From: Contact Centre (CRM) <contact@ribblevalley.gov.uk>
Sent: 06 June 2023 21:24
To: Planning
Subject: Planning Application Comments - 3/2023/0352 FS-Case-521976041

Planning Application Reference No.: 3/2023/0352

Address of Development: 10 Manor Road, Whalley BB7 9TE

A2.2

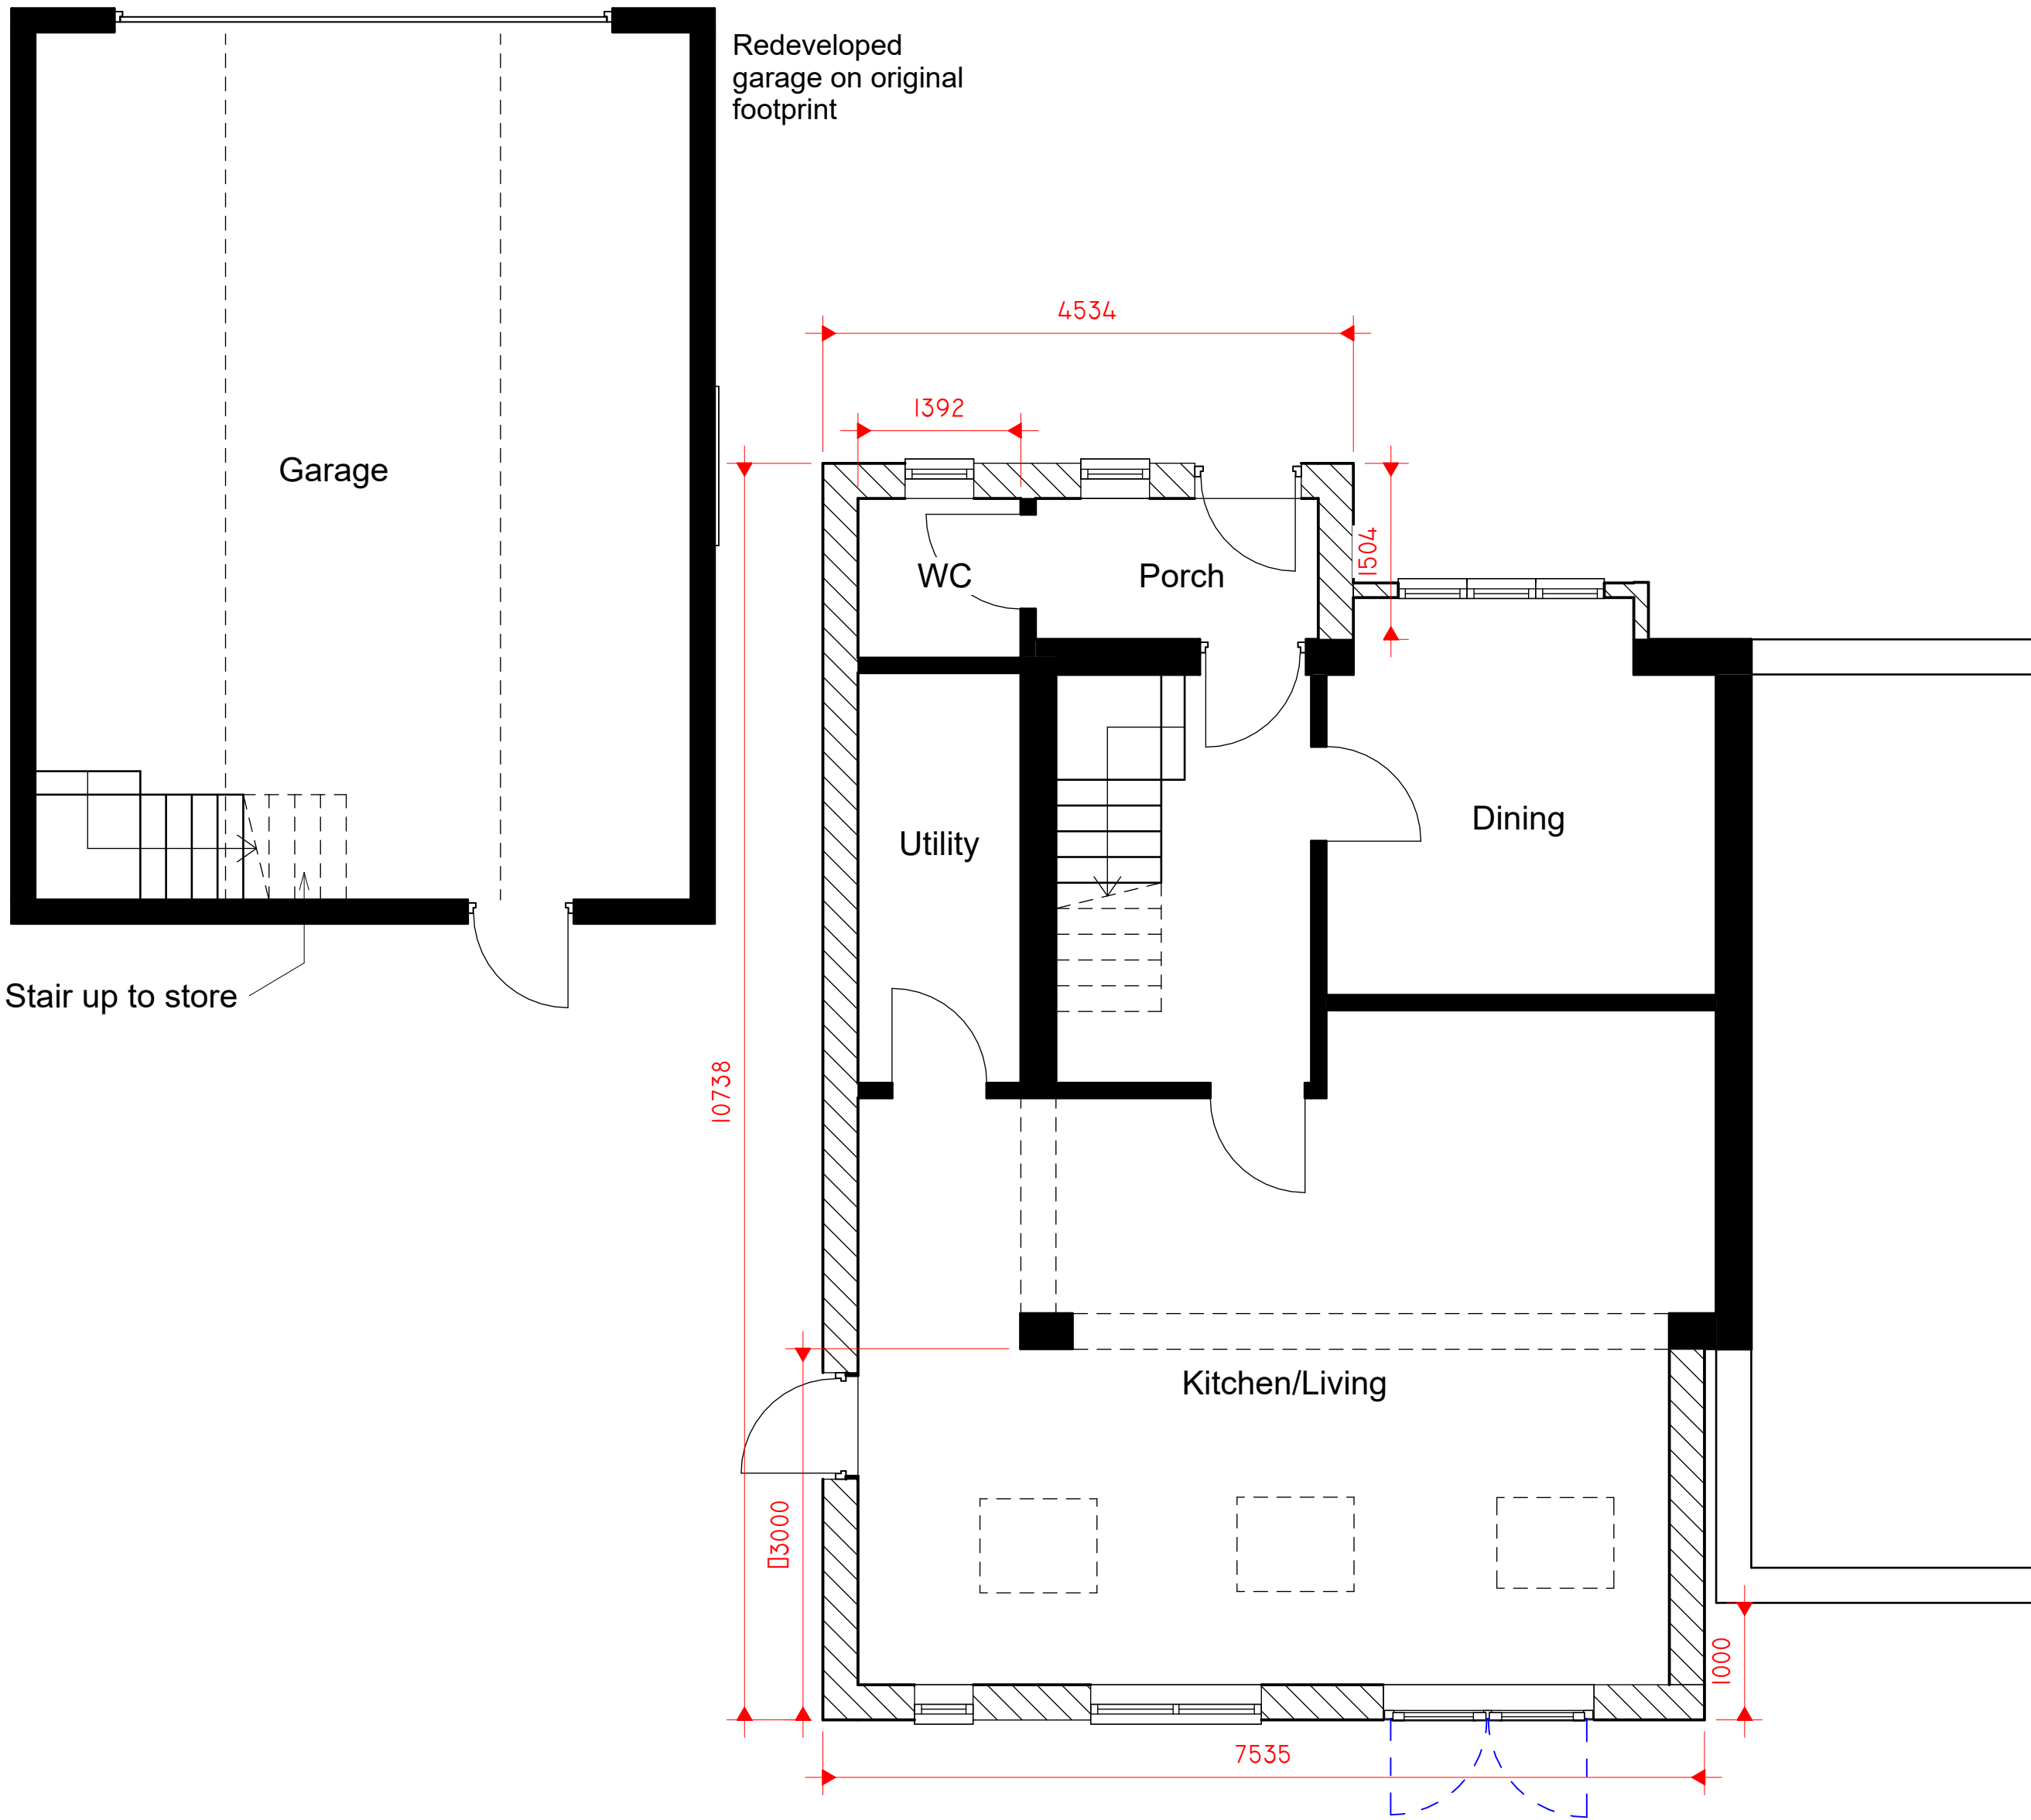
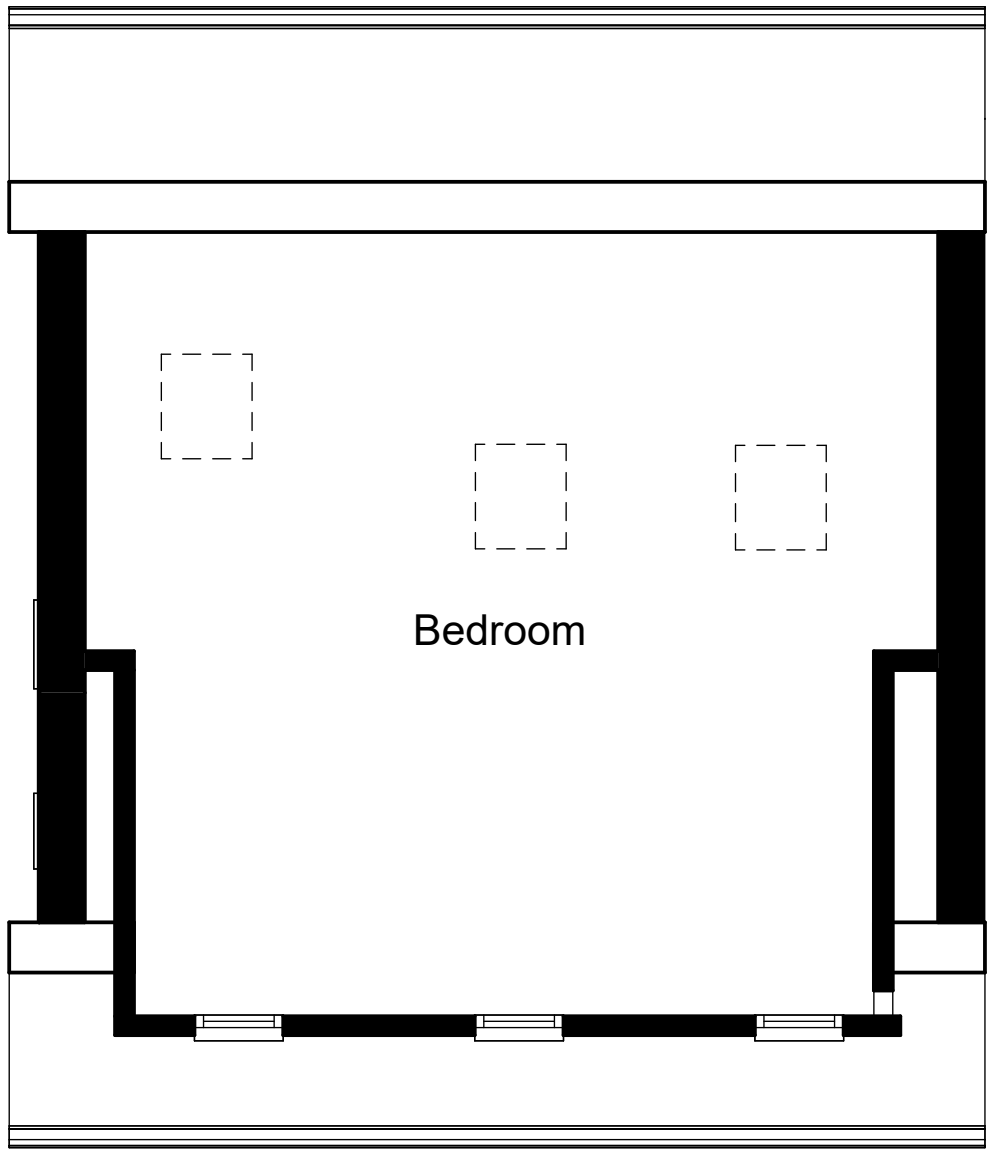
- 1) Confirm the rear extension (that is [REDACTED] will be constructed wholly on the land of no 10 Manor Road - [REDACTED] Out of interest not received any correspondence in relation to the [REDACTED]...which I'd have thought would be necessary ?Would also be interested to know if the owner/contractor believes they'll be accessing [REDACTED] actually construct this rear extension ?
- 2) Because the proposed rear extension is to extend 1m beyond its correct line/footprint, which means the existing lean-to roof will be at a different angle, what is the intended arrangement/detail between the new lean-to roof and next door (where the steeper pitch remains the same);
- 3) Not sure if square bay windows are to be constructed or angled bays - as the proposed plans show square and the elevations show angled (while not particularly bothered either way - would be good to know).
